POROUS LANDSCAPE DETENTION GRADING
7340 UTAH LANE
EL PASO COUNTY, COLORADO

PCD File # PPR 19-024

GEC_v3_redlines.pdf Markup Summary

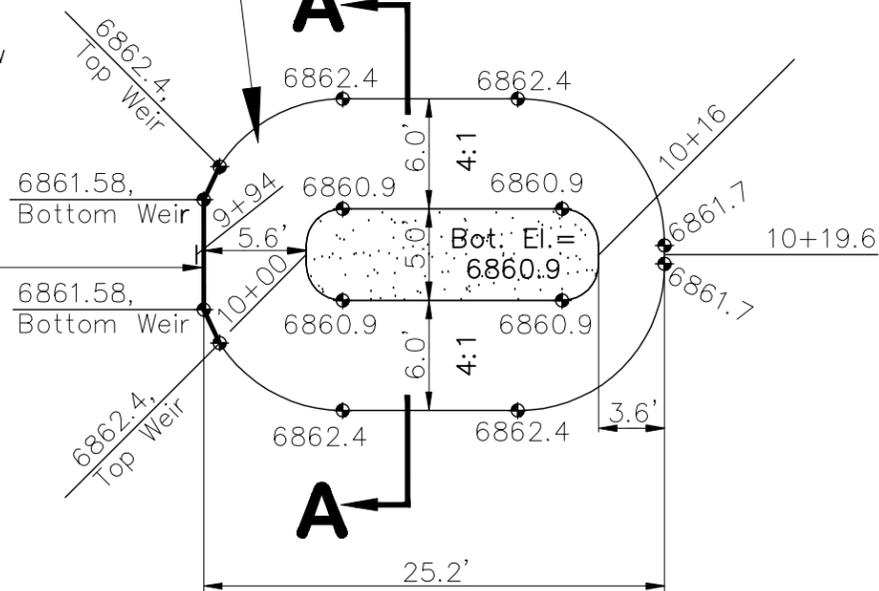
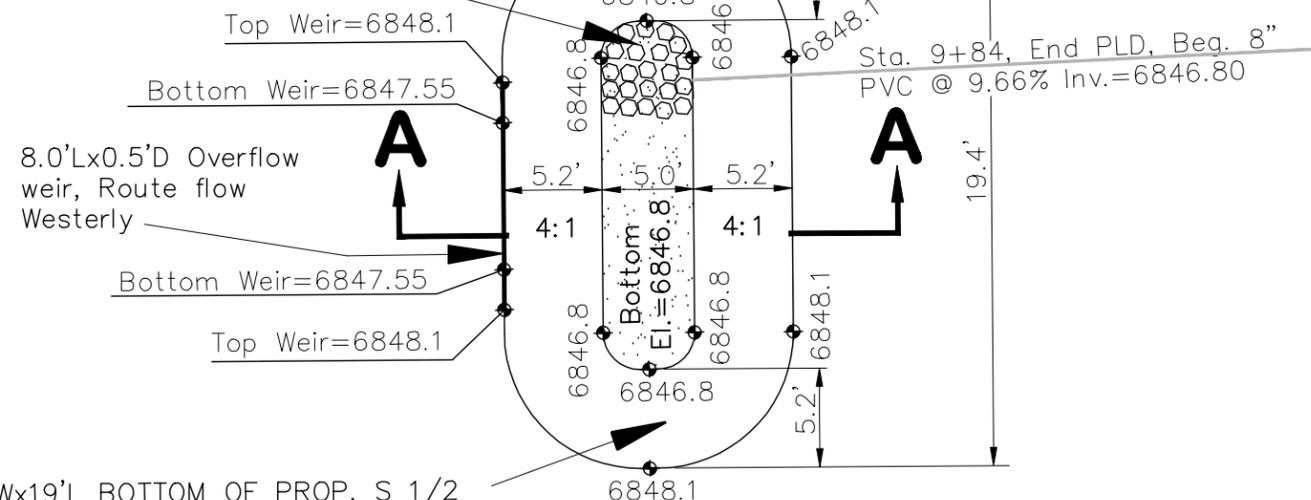
there are missing pages.
please include all sheets
with the re-submittal. Also,
please provide a place for
the ECM administrator to
sign.
